Your Reference: MP 07_0158
Our Reference: RDC 11M1663
SYD 11/00470
Contact: Sevda Huseyin
Telephone: 8849 2914

**SYDNEY
REGIONAL
DEVELOPMENT
ADVISORY
COMMITTEE**

**EXHIBITION OF ENVIRONMENTAL ASSESSMENT FOR SYDNEY UNIVERSITY
ABERCROMBIE PRECINCT REDEVELOPMENT (MP07_0158)**

Drawing title
BASEMENT FLOOR PLAN

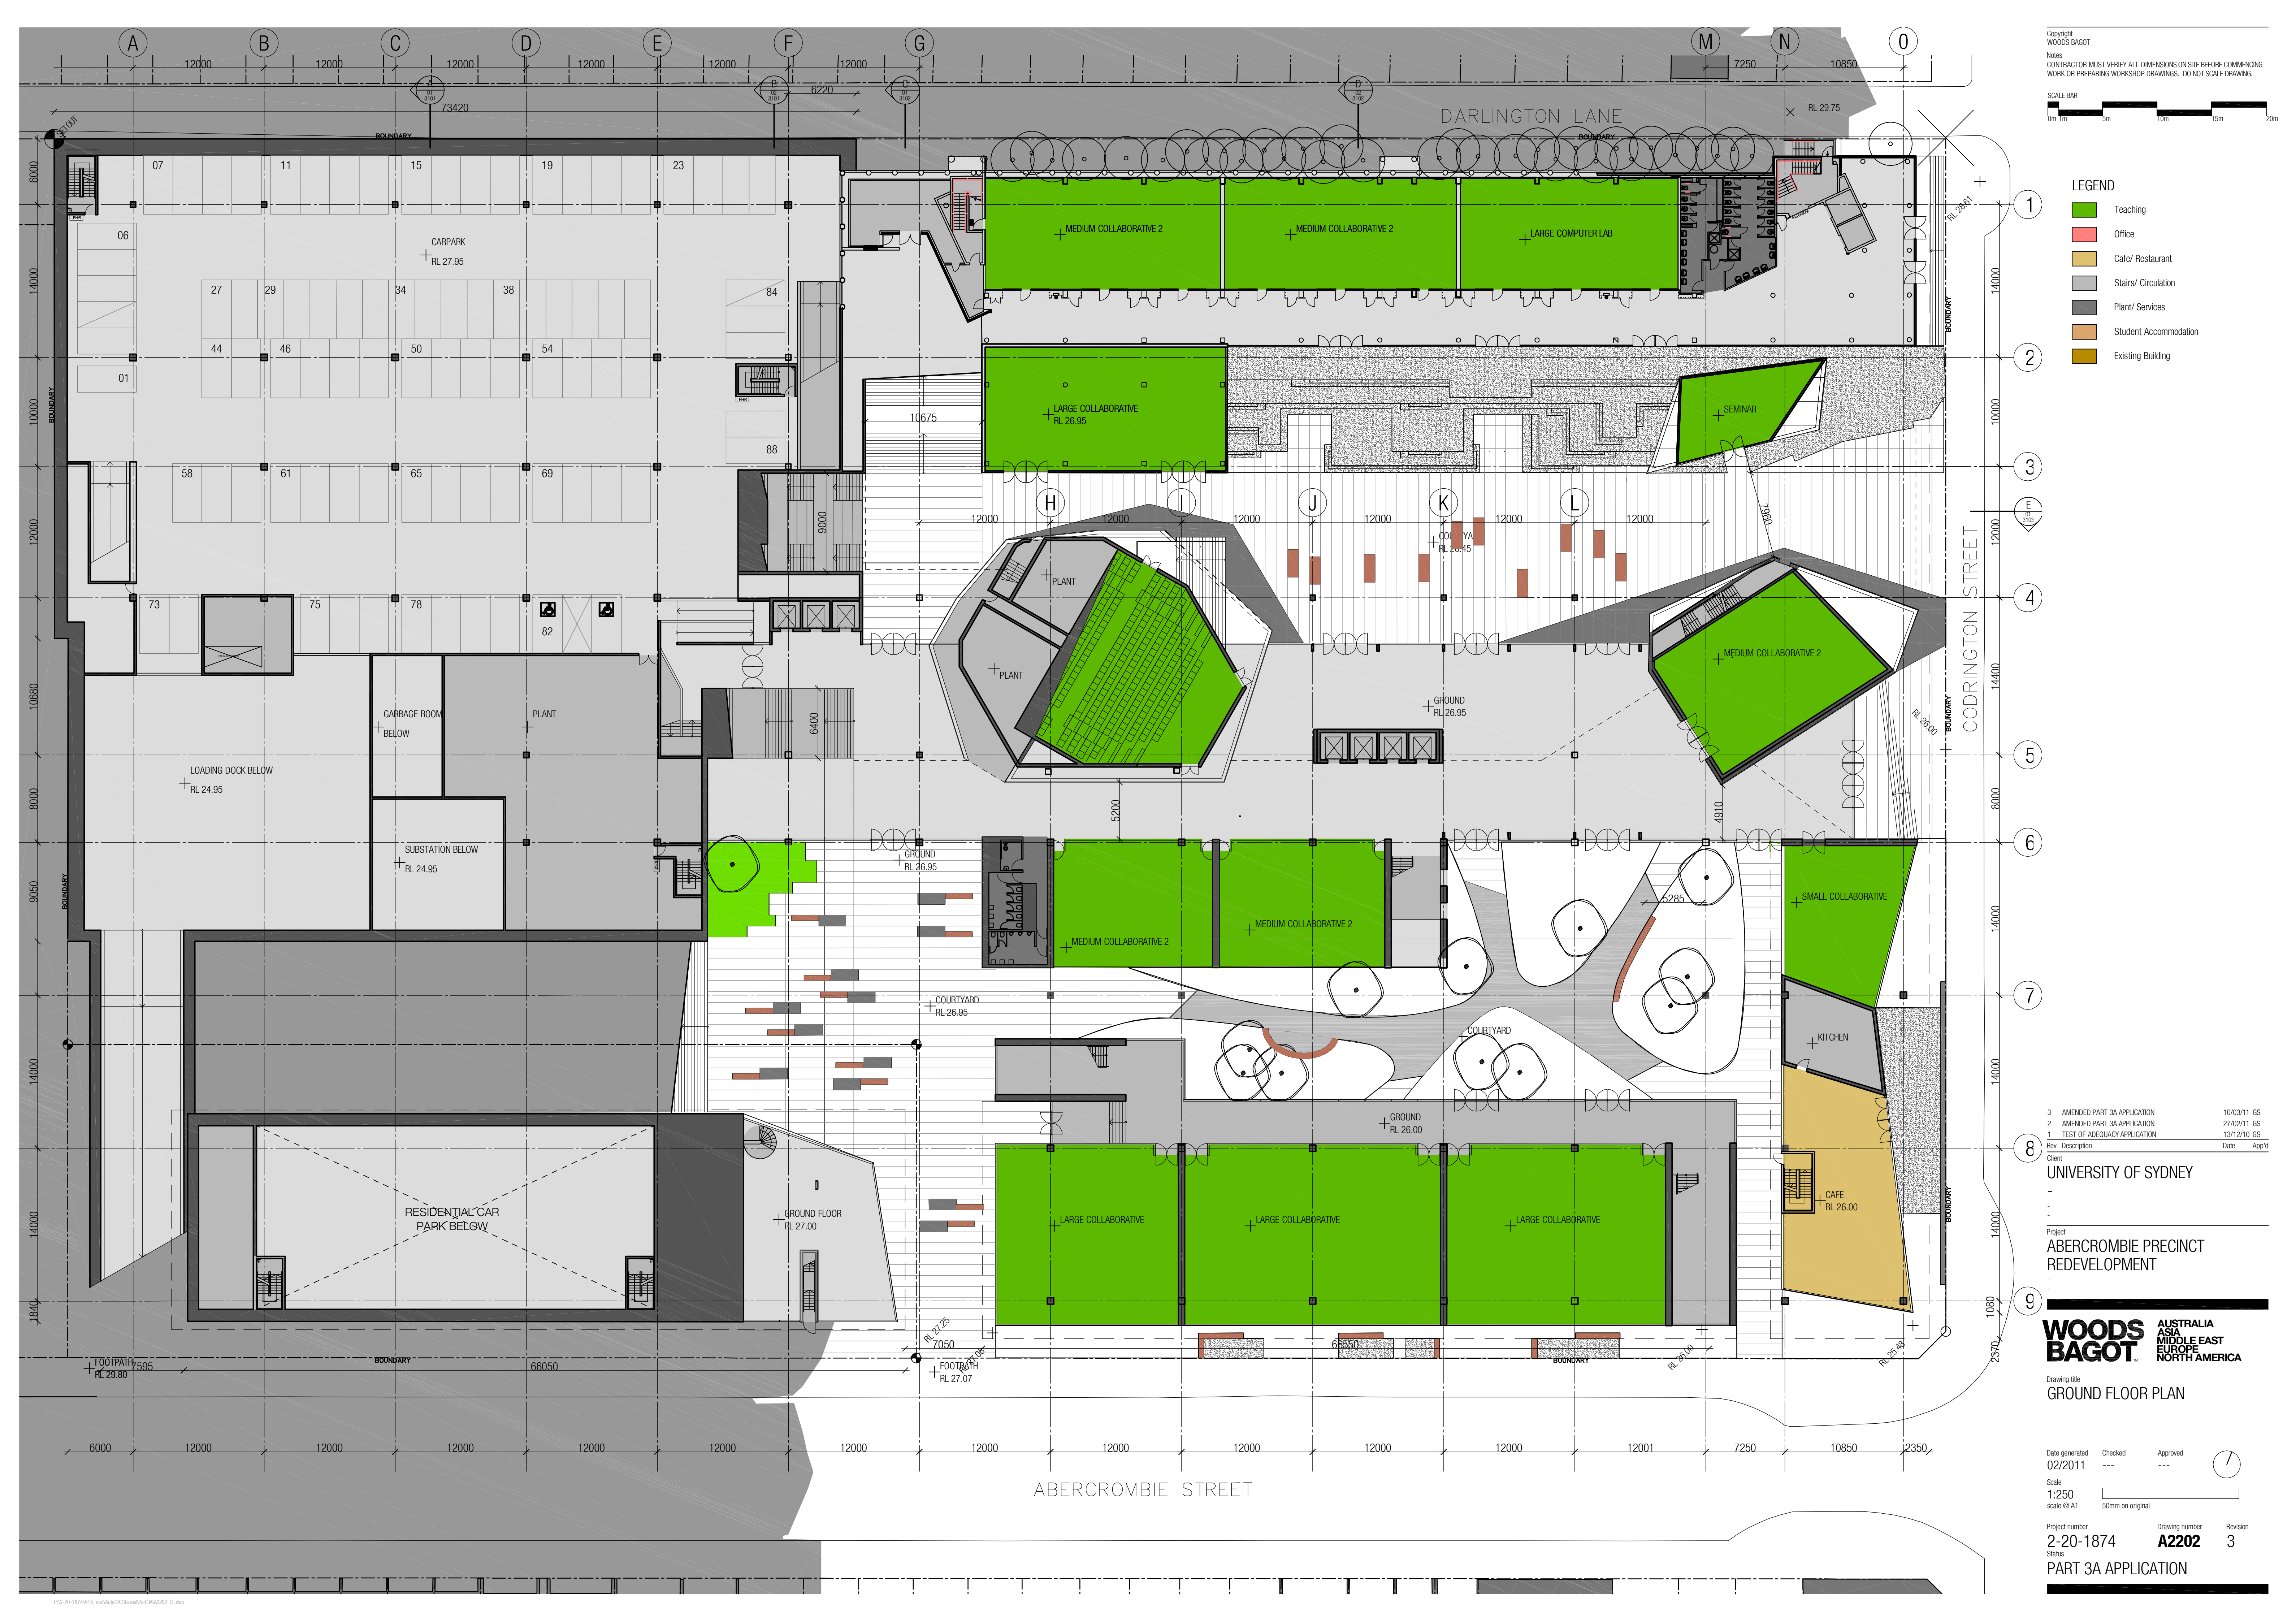
2. The layout of the proposed car parking areas associated with the subject development (including, driveways, grades, turn paths, sight distance requirements, aisle widths, aisle lengths, and parking bay dimensions) and end of trip bike facilities should be in accordance with Council requirements and AS 2890.1 – 2004 and AS 2890.2 – 2002.

3. All vehicles shall enter and exit the site in a forward direction.
4. A Demolition and Construction Traffic Management Plan detailing construction vehicle routes, number of trucks, hours of operation, access arrangements and traffic control should be submitted to Council, for approval, prior to the issue of a construction certificate.
